Re: Town & Country Planning Act 1990

Application ref: P/~~47/11~~ - 52 East Front Road Pagham

Proposed new extensions 52 East Front Road Pagham

For	Mr and Mrs Evers	Date	24.05.2011	Dwg by	SK	Revision	C
Title	PROPOSED LAYOUT GROUND FLOOR PLAN	Scale	1:50	Project no	126	Dwg no	P1

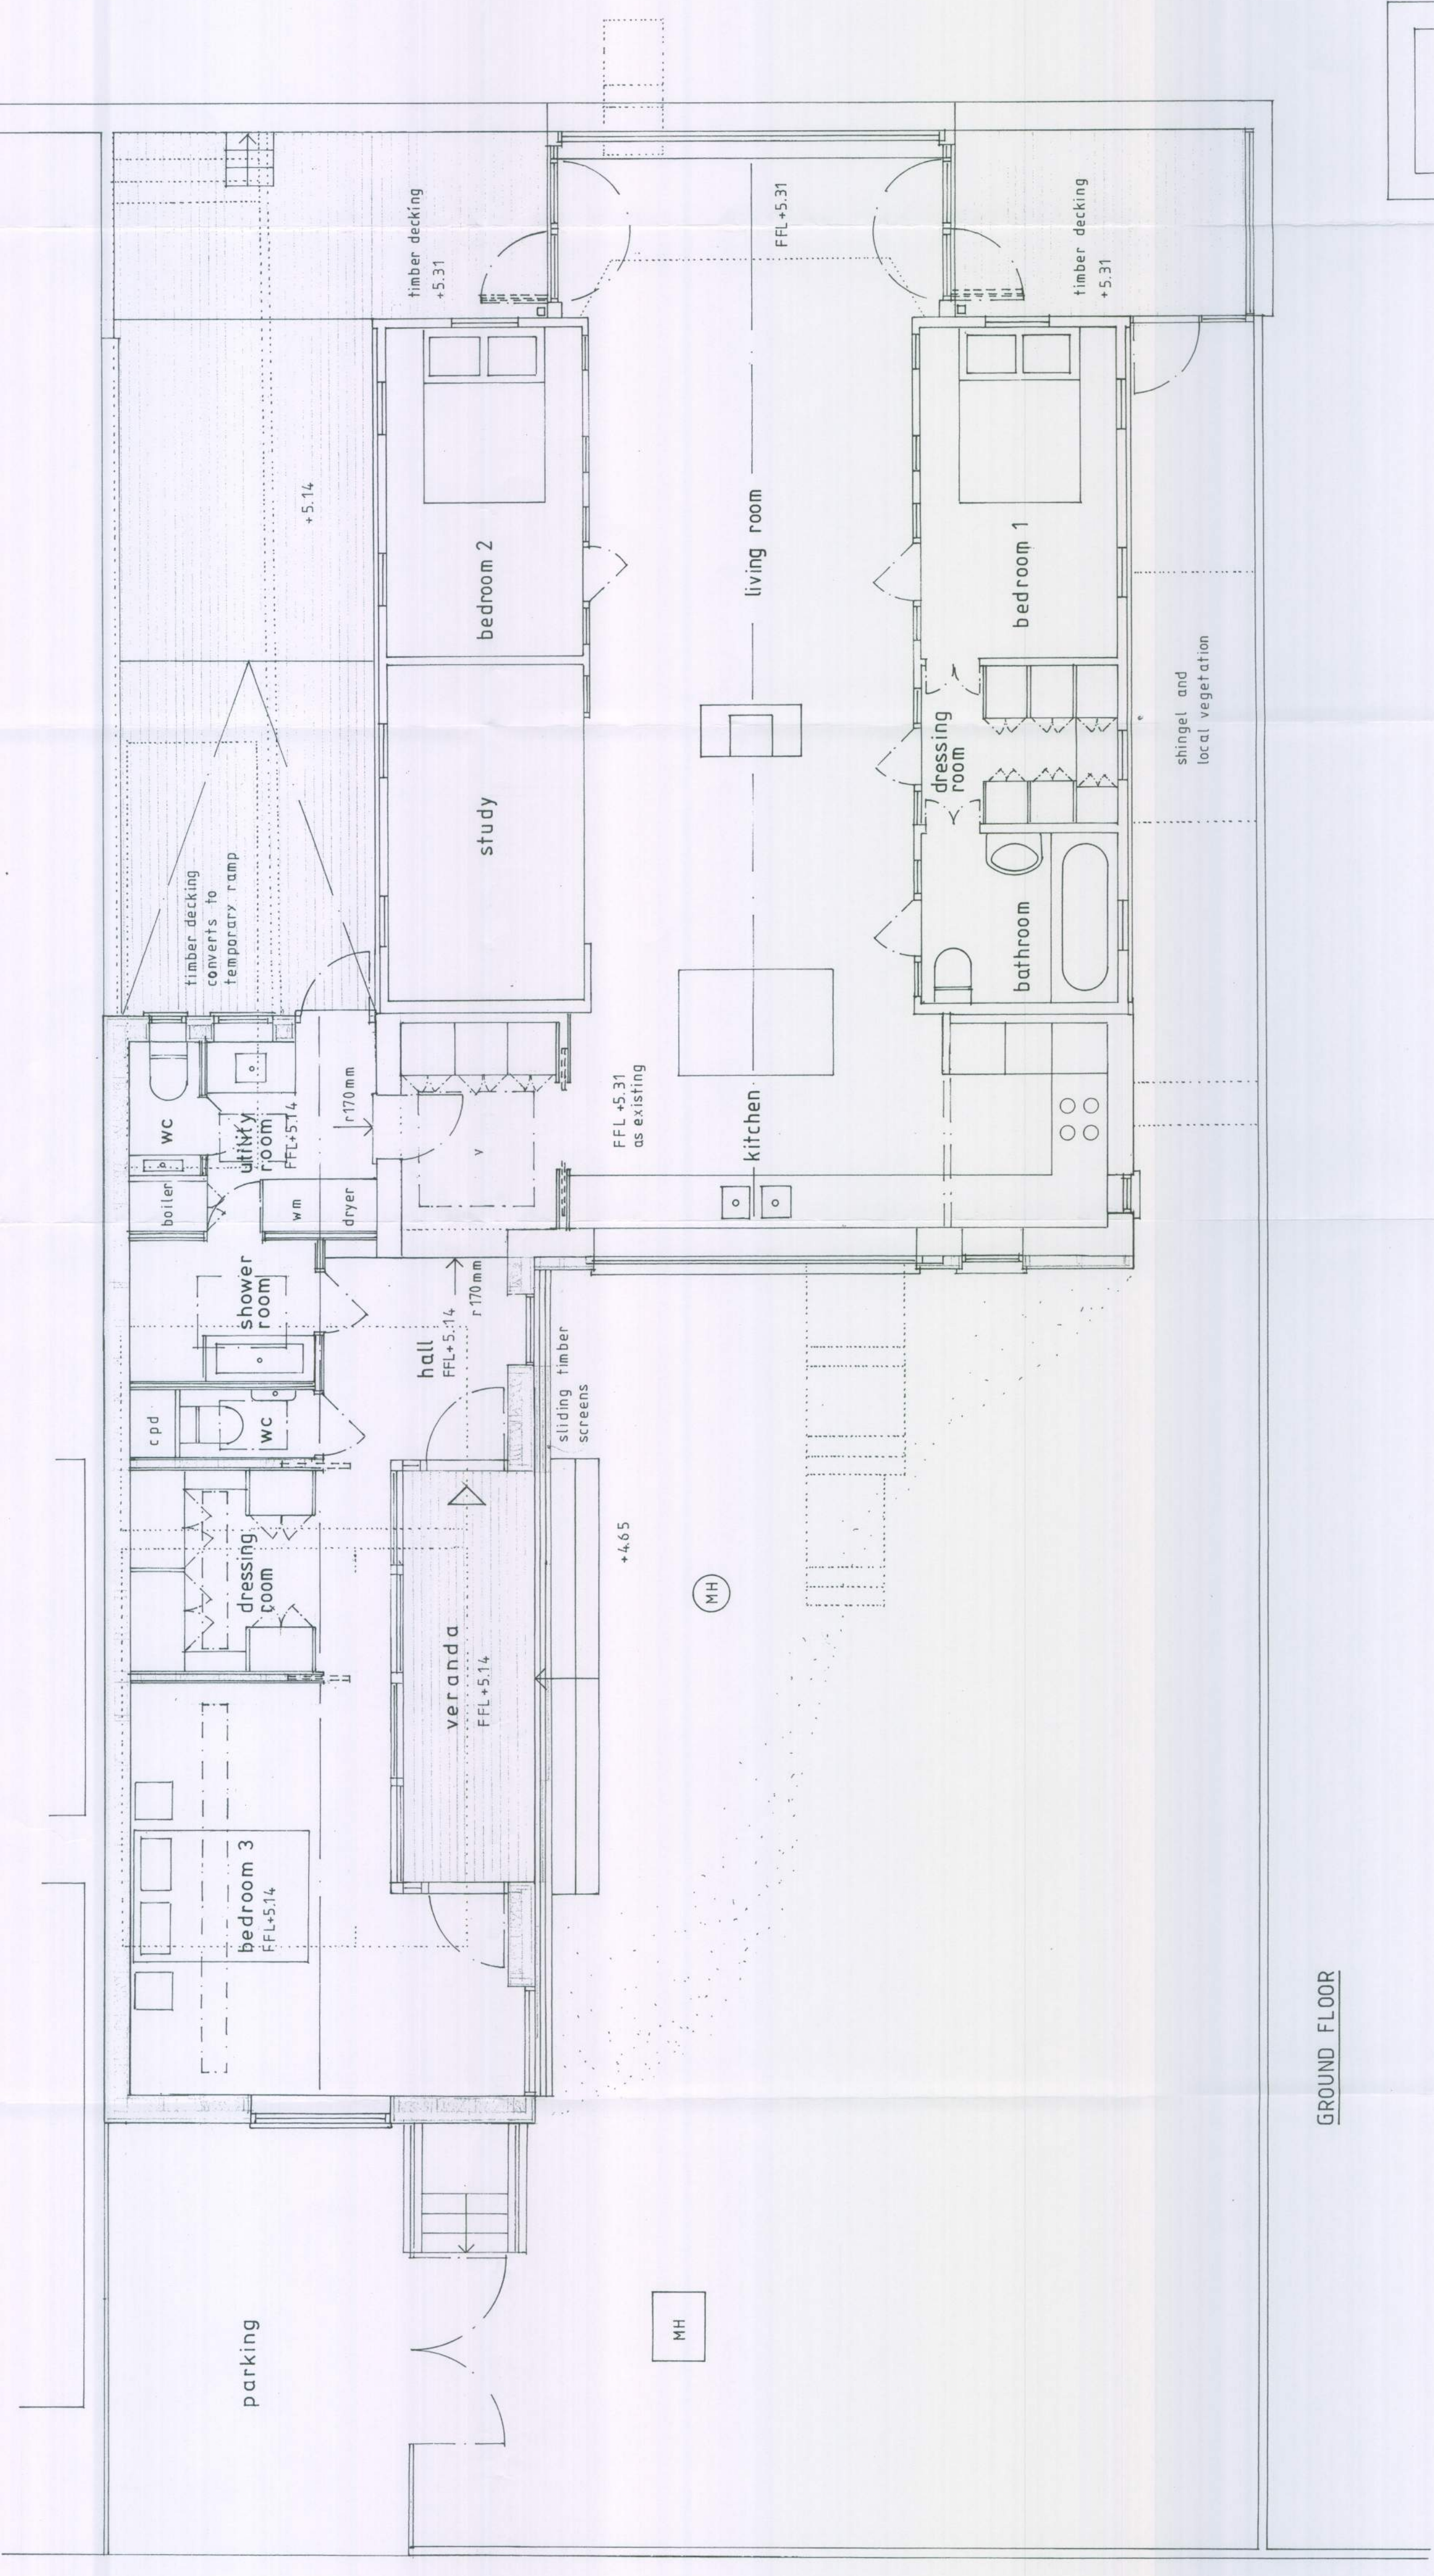
The owners propose to build ON THE BOUNDARY which is 1660mm from our toilet/bathroom and bedroom on the west side of our property. This is too

close for decent privacy and comfort. At the moment they too have a 1660mm wide approx pathway at the side of their property leaving a total space between properties of 3320mm. This mandatory distance has proved acceptable for all in the years since the properties were built in 1920-1925. It will be reduced to 1600mm.

iv) Below- ground room called "boat store"

Nobody I know has a "boat store" on Pagham Beach. Most people leave boats on the beach and always did. When we bought our property there was a small boathouse in the gap between our bungalow no 54 and 56 East Front road but I removed it to improve beach access for my own boat. I believe the real purpose of

this proposed room is a children's "rumpus" room and an occasional overflow habitation at times of increased guest accommodation etc. The proposer told me some while ago that there would be a rumpus room for his children and their friends included in the extension plans. He has chosen to use the above ground rooms for utility purposes and 1 new Bedroom but no new children's rooms or playrooms appear on the plans. The proposed new underground "boat store" is approximately 2.3 m high from floor to ceiling accessible from the north by a normal height door and is of a size for a rumpus room. We object to this possibility as we know that the boat has been stored outdoors all winter and would probably never see the inside of the euphemistically named "boat store". This is a sizable room which makes the extension a two storey extension - unacceptable within the local area plan. Other boat equipment storage spaces in other new builds in the road have been much smaller and not accessible by a 2metre high door.

- vi) Boiler emissions will be ejected straight into our property and garden where our grandchildren play and my wife and I intend to relax and enjoy our approaching retirement. If the breeze is offshore the boiler emissions will come along the new reduced width path and into my bedroom window on the front west carriage or into the front west corner window into our lounge.

This is totally unacceptable and the boiler needs to be sited on an external north or west wall to vent either to the North or West like other properties in this vicinity. We all have right to clean air and sunlight.
